LATIOG TRAILS - FILING NO. 9	GRADING AND EROSION CONTROL PLAN	DESIGNED BY	APL
		DRAWN BY	RWK
SHEET	7	OF	14
JOB NO.	25175.01

LATIGO TRAILS - FILING NO. 9

GRADING AND EROSION CONTROL PLAN

LATIGO TRAILS – FILING NO. 9	
GRADING AND EROSION CONTROL PLAN	
SHEET 6	OF 14
JOB NO.	25175.01

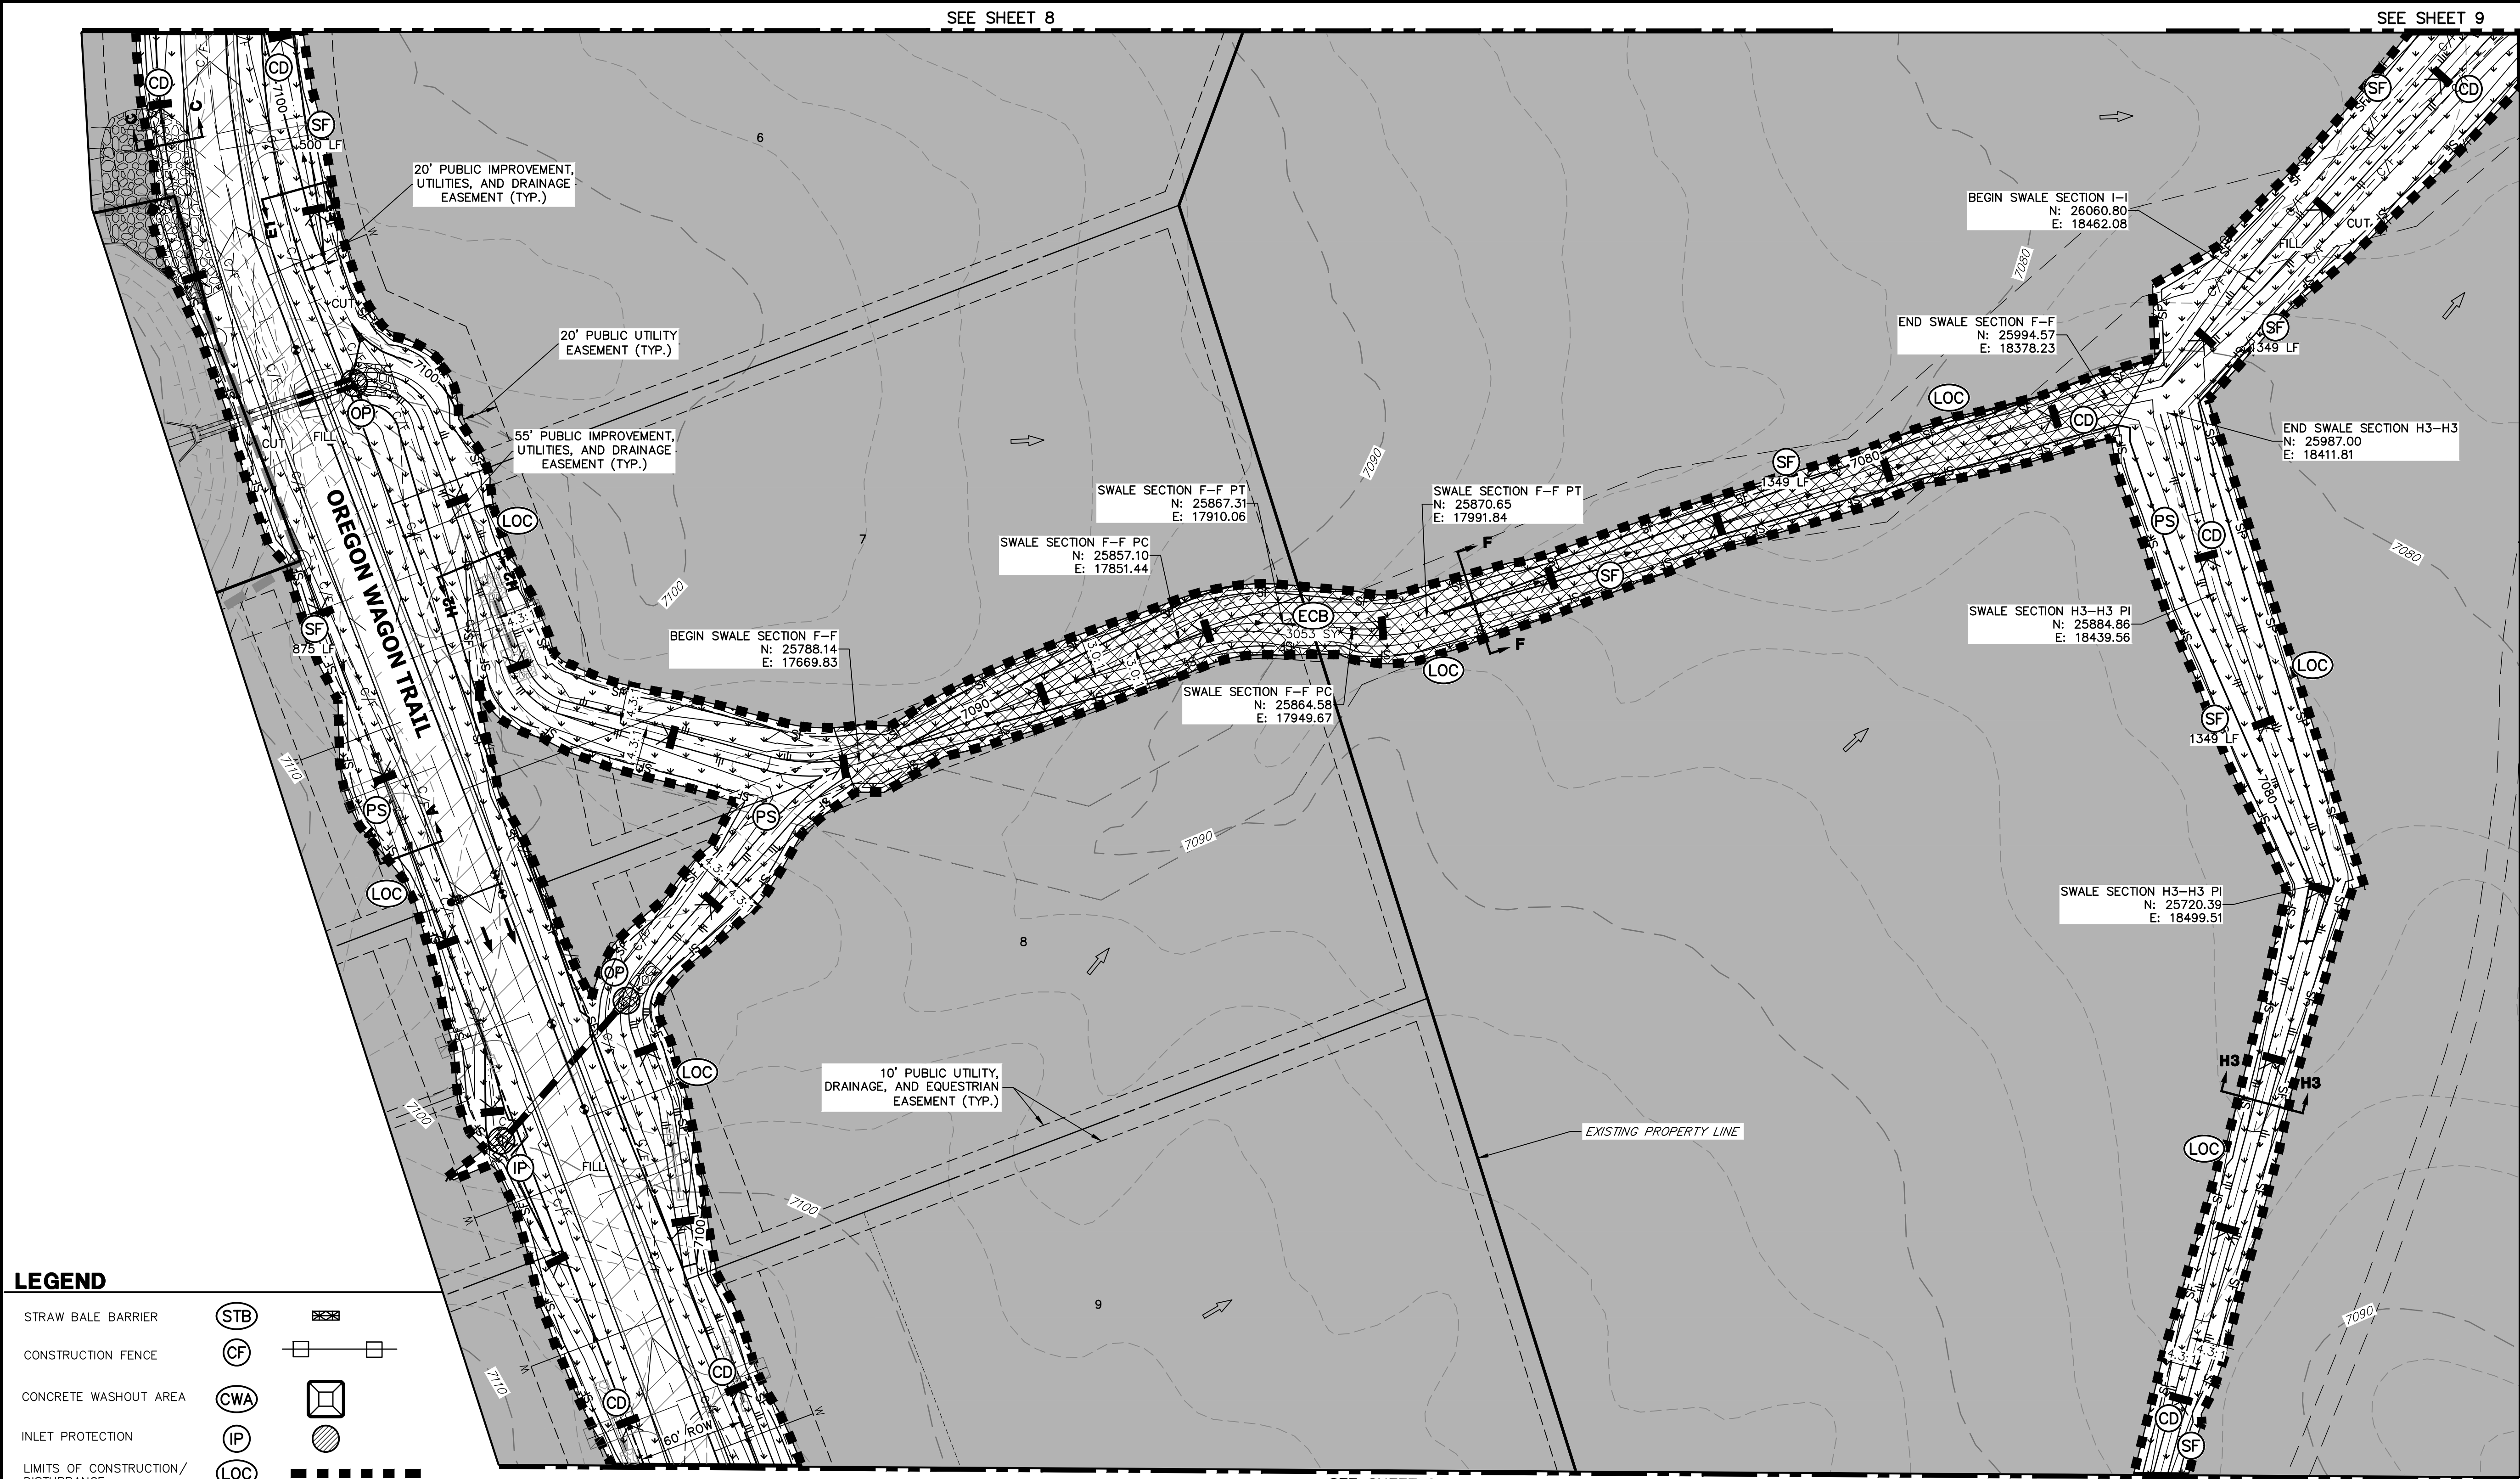
Checklist Item "o" --- At this location and others for this project:

Private Offsite Grading: Need owner permission to grade offsite. Provide copy of owner permission to EPC. Per Item O on GEC Checklist.
 - For a small amount of grading, applicant to submit as discussed above.
 - For a larger amount of grading, owner AND applicant will need to sign GEC/CD's.

Public Offsite Grading: Call out as offsite grading, to be approved by the City of Colorado Springs (or EPC).

Check dams to be installed a minimum of every 1.5' of vertical fall. Notate spacing and/or include a table for multiple slopes, based on your selected detail, per the example table shown to the right.

Slope of Ditch Flow Line	2%	3%	4%	5%	6%	Reference	Type
Spacing (ft) (H = 0.5ft)	25	16.7	12.5	10	8.3	CDOT, MHFD, DCMv2	SCL (9" Straw Wattle, buried 3")
Spacing (ft) (H = 1.5ft)	75	50	37.5	30	25	MHFD	Rock
Spacing (ft) (H = 2.0ft)	100	67	50	40	33	CDOT	Rock
Spacing (ft) (H = to convey 2-yr flow)	TBD	TBD	TBD	TBD	TBD	DCMv2	Rock
